City of Portland, Maine - Building or Use Permit Application

Permit No: 02-0952	Issue Date: SEP 11 2002	CEB#: 336 L030001
-----------------------	----------------------------	----------------------

Proposed Project Description:
Build 24' x 24' 6" Garage / Master Bedroom

Re: 5 Hillcrest Circle/Gullbrand Job Specifications

5 HILLCREST CIRCLE
PORTLAND, MAINE

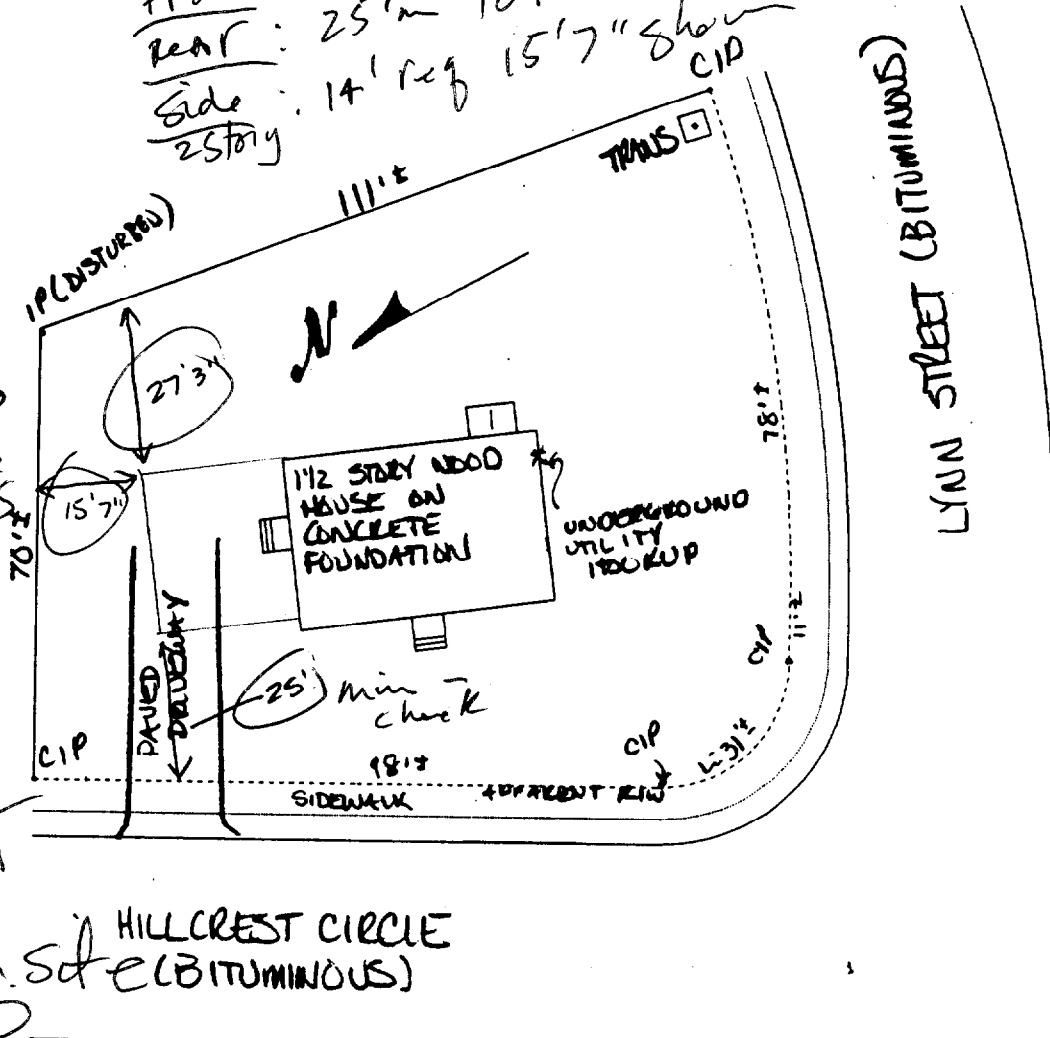
R-2
Front: 25' min to Front Property Line
Rear: 25' min to REAR Property Line
Side: 14' req 15'7" shown
2 story CIP

8/27/02 spoke with Mark M. in office about the setbacks to property lines NOT the side walks. - he HAS the pins & HAS string These measure ments already - I told him that the code enforcement officer would be measuring on side (BITUMINOUS)

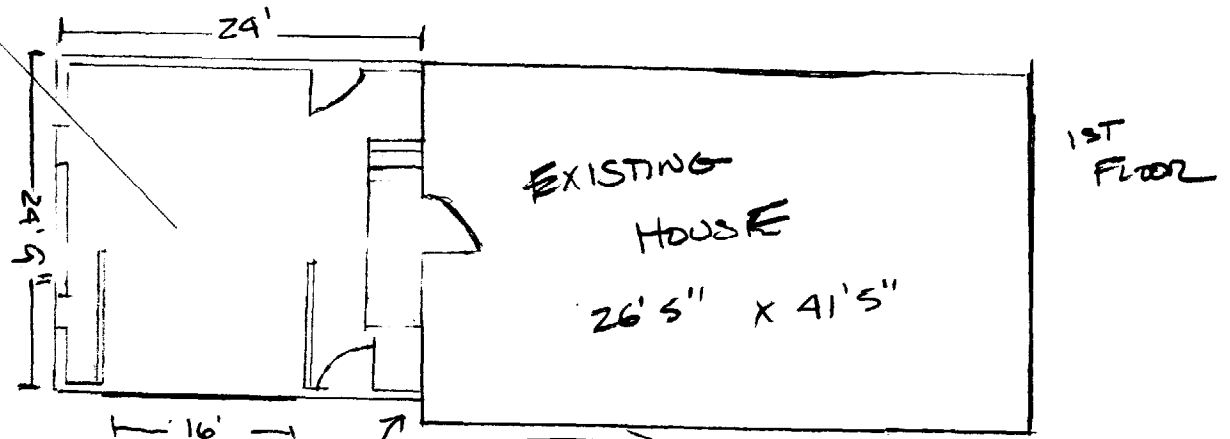
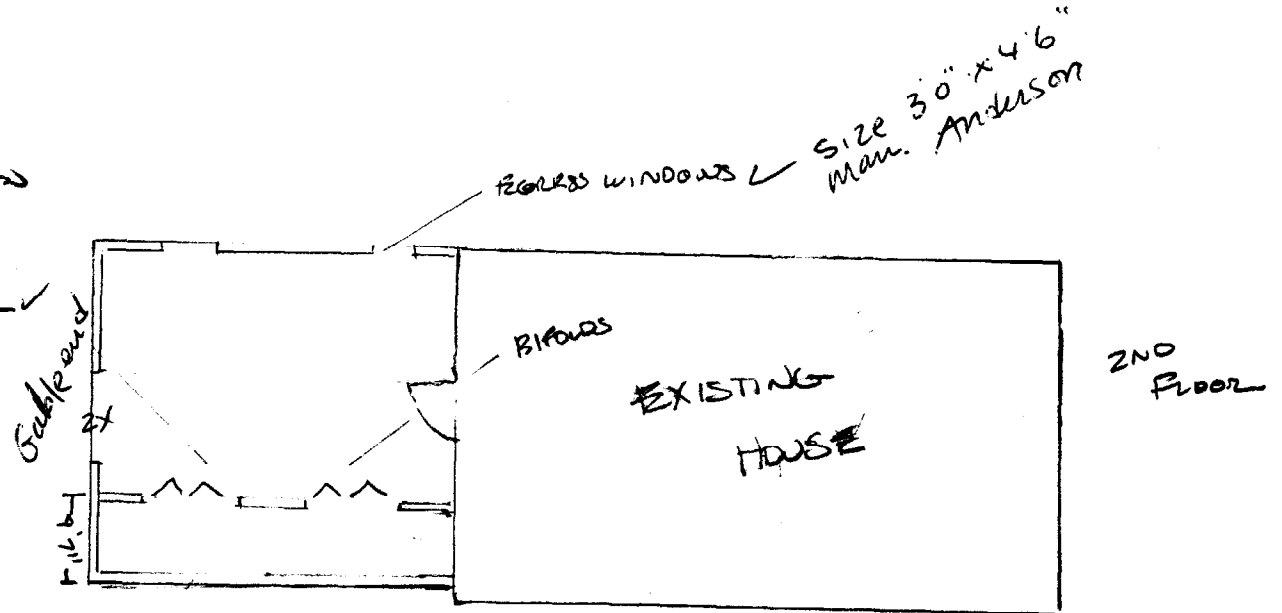
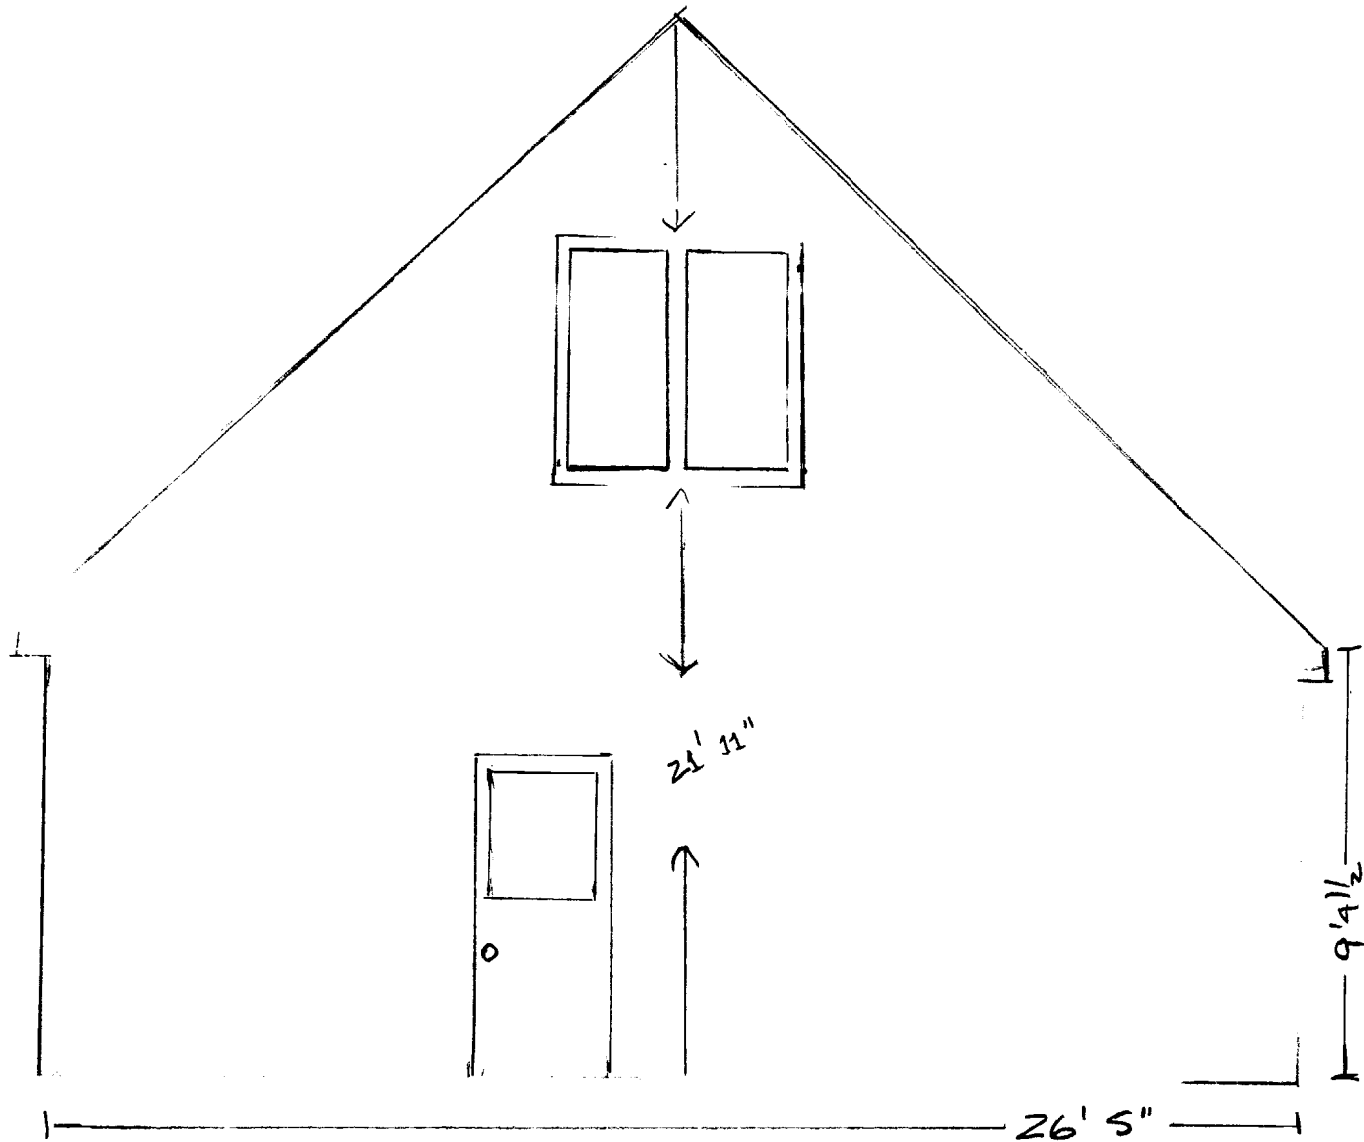
W1430 STEEL BRAM NEED SPEC

- 2 x 6 exterior wall construction
- 2 x 10 2nd floor joists 14' long supported by a center beam
- W1430 center beam supported by solid and continuous 2 x 8 posts to floor/foundation. Beam to span 23'6" and is centered on 24'9" wall.

Tripled Boise Cascade Verso Lam
